MP06_0295 MOD 10: Cadia Valley Operation Molybdenum Recovery Plant Relocation Modification Response to Submissions (RtS)

Roads and Maritime Services

MP06_0295 MOD 10: Cadia Valley Operation Molybdenum Recovery Plant Relocation Modification

Figure 3

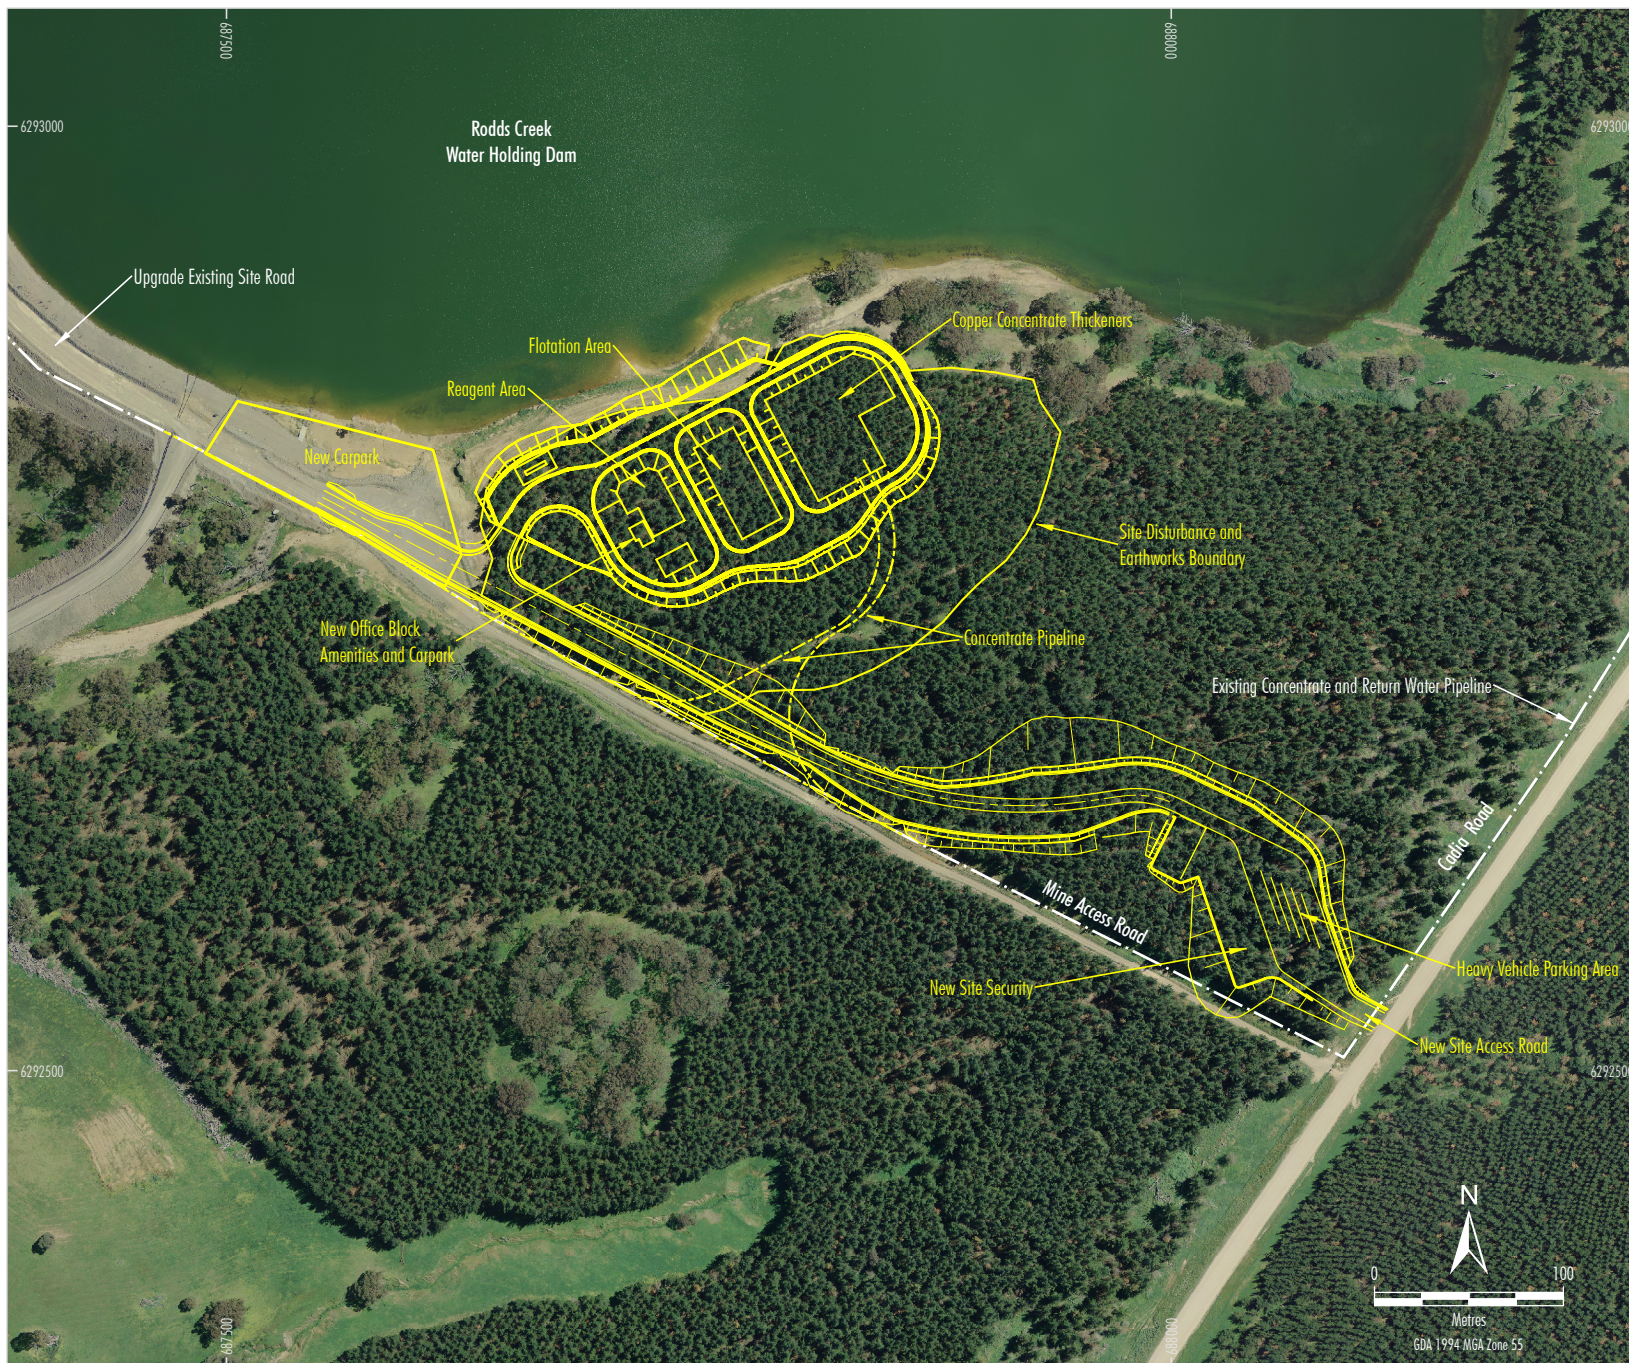
The documentation submitted in support of the proposal has been reviewed. Roads and Maritime notes the proposed modification involves the relocation of the Molybdenum recovery plant to a new location adjacent to the Rodds Creek Water Holding Dam. A new vehicular access from Cadia Road is also proposed. The proposed modification will not change the existing approved operational staffing numbers at the mine. Modification 10 has been referred to Roads and Maritime pursuant to section 16 of *State Environmental Planning Policy (Mining, Petroleum Production and Extractive Industries) 2007*.

- Safe Intersection Sight Distance in accordance with Part 4A of *Austroads Guide to Road Design* is to be provided and maintained at the proposed vehicular access intersection with Cadia Road.
- Haulage operations and shift changeover times coinciding with local student school bus pick up/drop off times are to be avoided.
- In accordance with clause 16(1) of *State Environmental Planning Policy (Mining, Petroleum Production and Extractive Industries) 2007*, the applicant is to prepare and implement a driver code of conduct for the task of transporting materials on public roads.
